Trans Pennine Trail ®

Planning Application Response

Organisation:	Barnsley Council
Detail:	Erection of single storey sub-station – land adjacent to St Mary's Street and TPT, Penistone
Planning Ref:	2026/0394
Link:	Application Details
Closing Date:	26 th June 2026 (extension agreed)
Response to:	GeorginaBrayford@barnsley.gov.uk
Submitted by	Trans Pennine Trail National Office
Date:	24 th June 2026

Layout

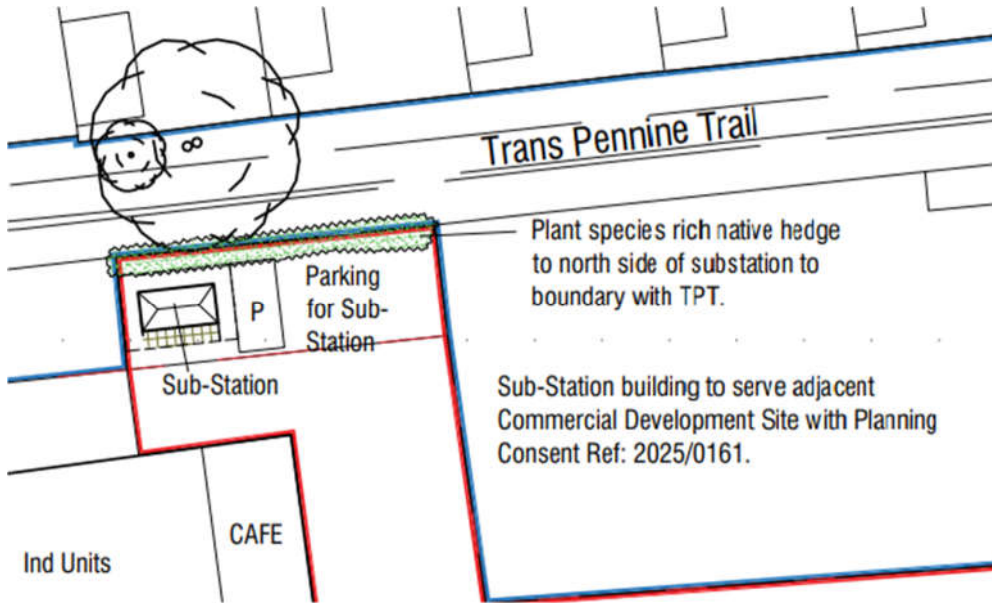
Noted the removal and replanting of native hedge along the TPT which will support the screening of the TPT from the development. This is supported.
